Our Ref: DOC18/332280
Your Ref: MP10_0167 MOD 2

Re: Section 75W Modification of consent (MOD 2) – Belle O'Connor Street, South West Rocks

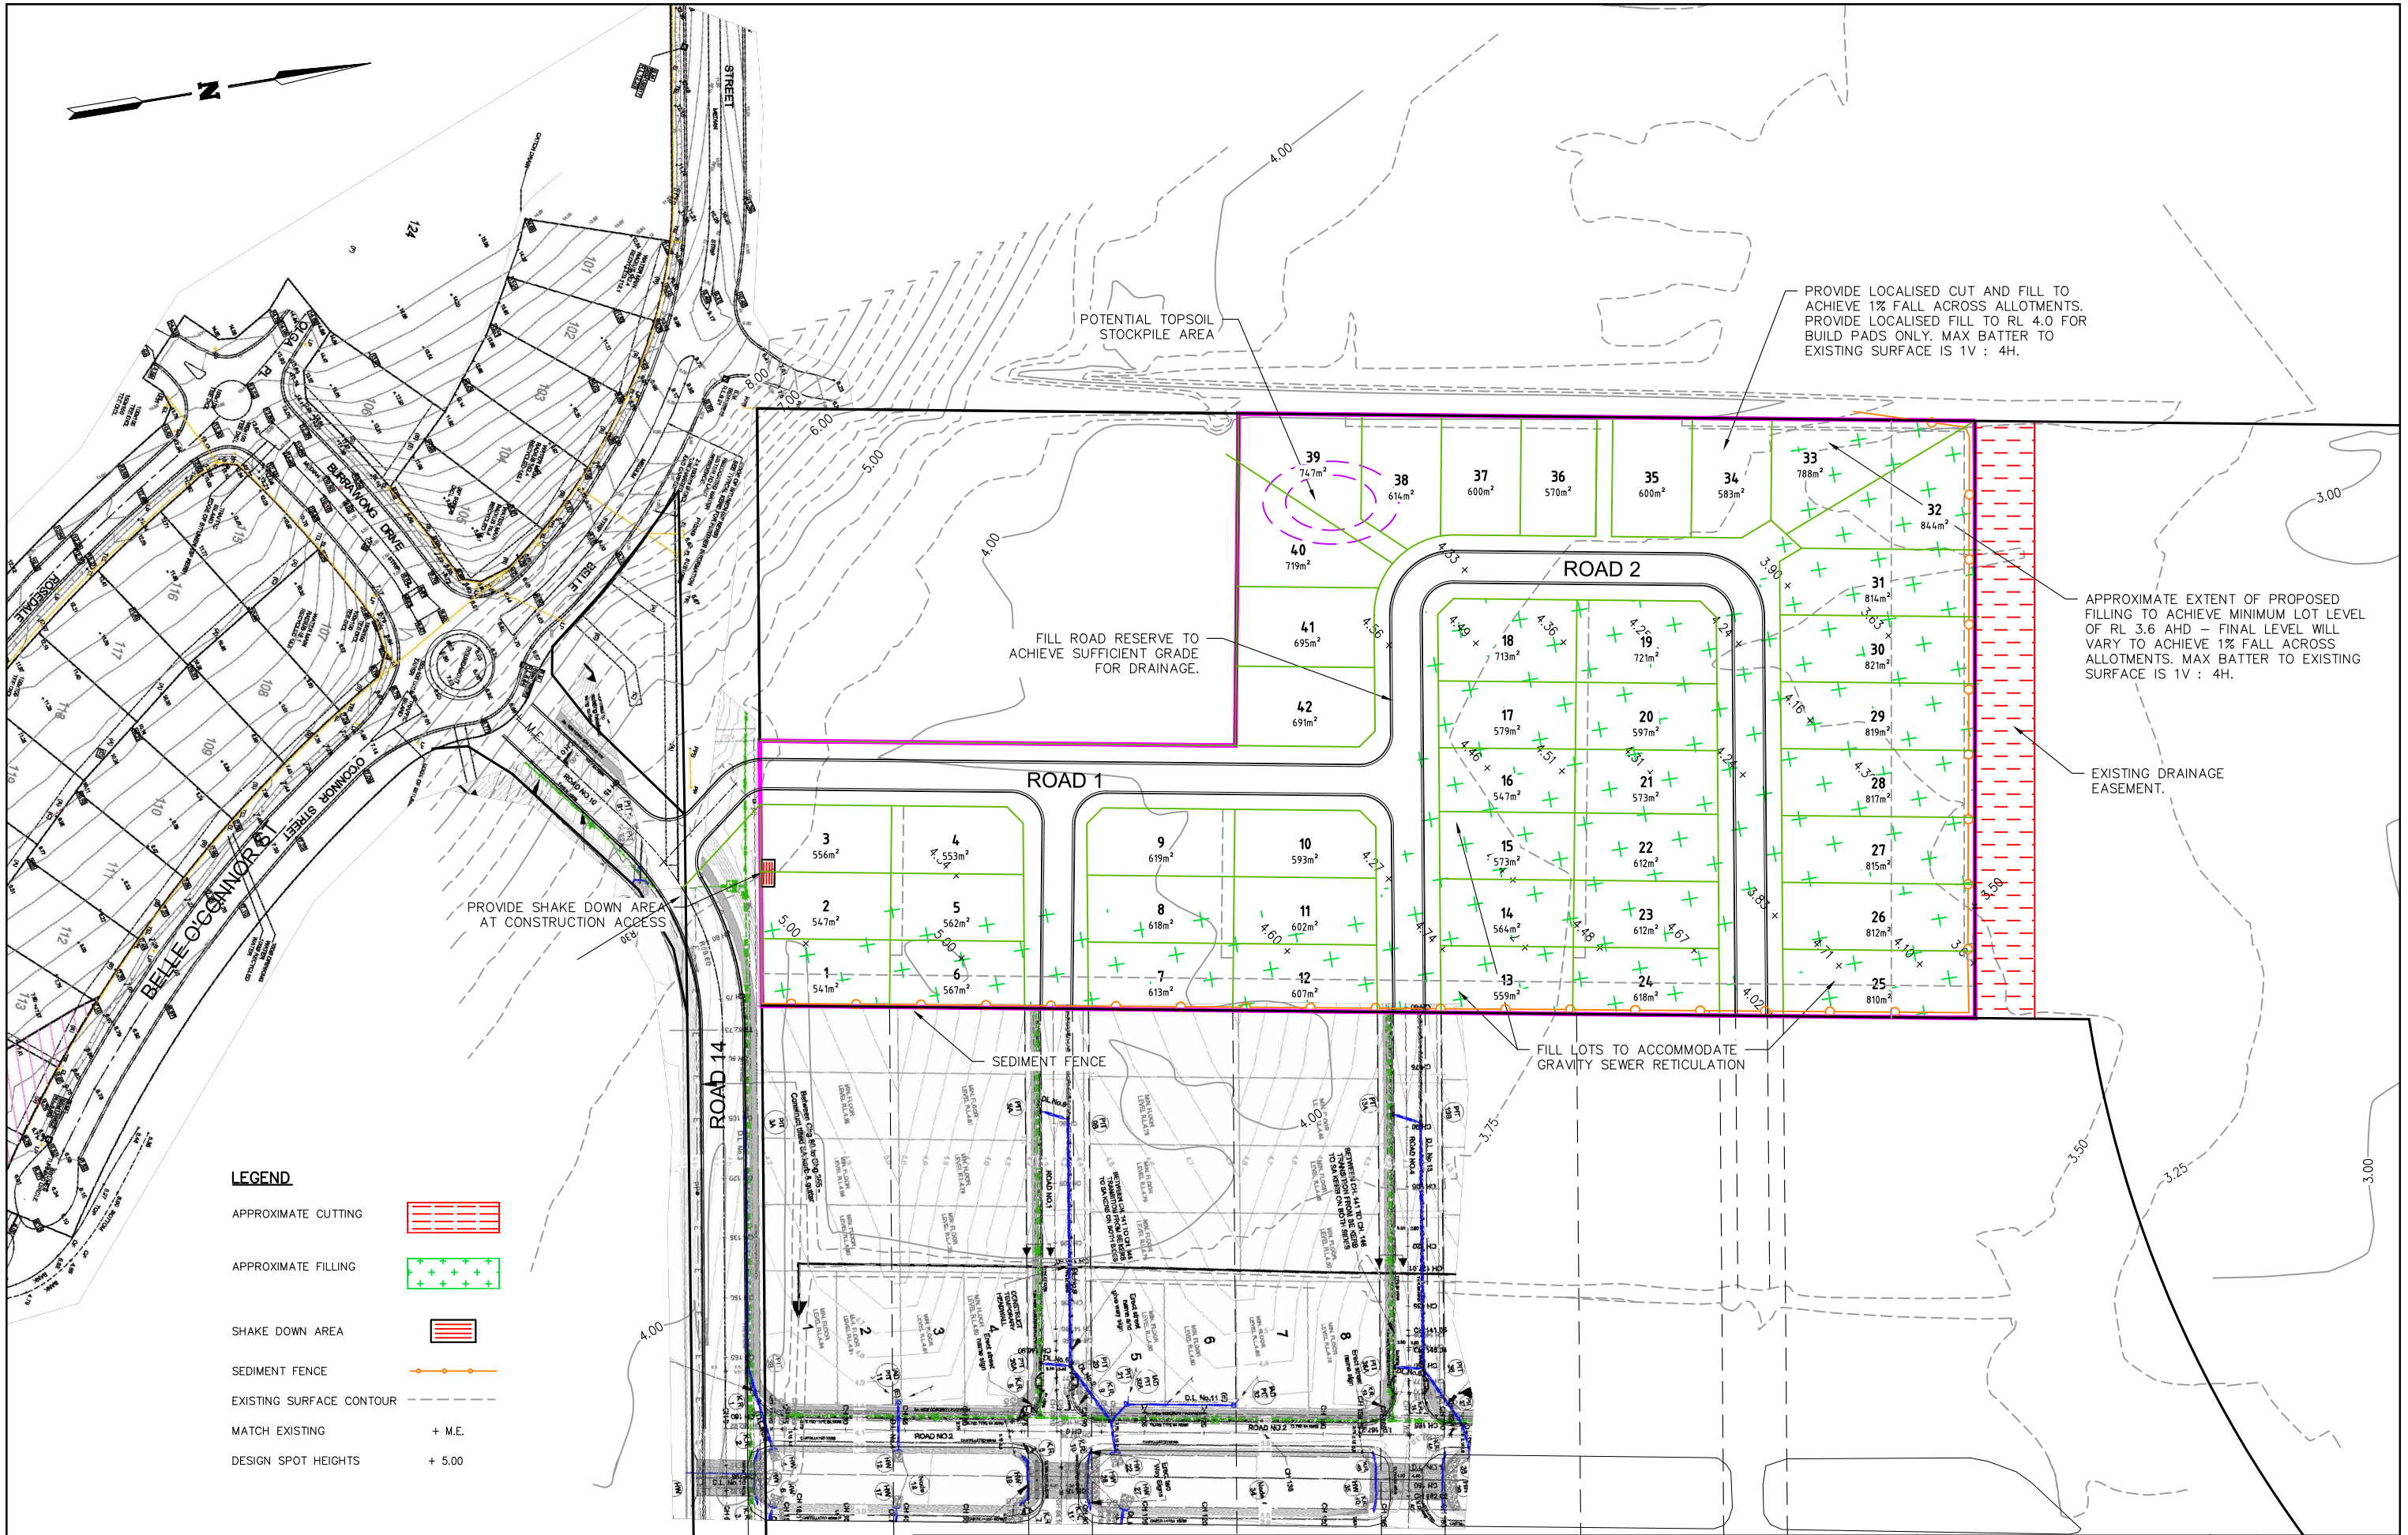
However, we now further understand that the RFS may require a boundary fire trail of six metres width and a proposed APZ of unknown extent for the fire trail itself.

The OEH is uncertain whether the proposed fire trail has been approved by the Department of Planning and Environment (DPE) as a defined condition within its original determination. If it has been made as part of another Modification then this has not been made clear when we previously commented. If so, then this development infrastructure impact has not been assessed and included when the original offset area was negotiated.

Certainly, any additional fire trail and/or APZ requirement within the Conservation Zone would not only be inconsistent with the DPE's original Assessment Report (p. 17) but would also be an additional development infrastructure impact and require further assessment and an additional offset to be provided.

Depending on the legal status of the proposed fire trail, its location and a clarification regarding RFS requiring an APZ over the fire trail, by implication within the E2 Zone, then the proposal may not be consistent with the DCP in the following areas.

1. the requirement for, and the legal location of, a boundary fire trail and Asset Protection Zone should be reconsidered and clarified;
2. depending on the outcome of recommendation 1 above, a further assessment and discussion of additional biodiversity impacts, possibly within the proposed Conservation Zone, should be provided and assessed as necessary;
3. depending on the outcomes of recommendations 1 and 2 above, an additional biodiversity offset should be provided if required, and any such additional offset should be proportionally established in accordance with the proposed Mod 2 staging; and
4. a suitable mechanism should be proposed for the dedication and rehabilitation of the 3.7 ha (or possibly larger) proportional conservation offset area specifically linked to the Stage 10 and 11 approvals.
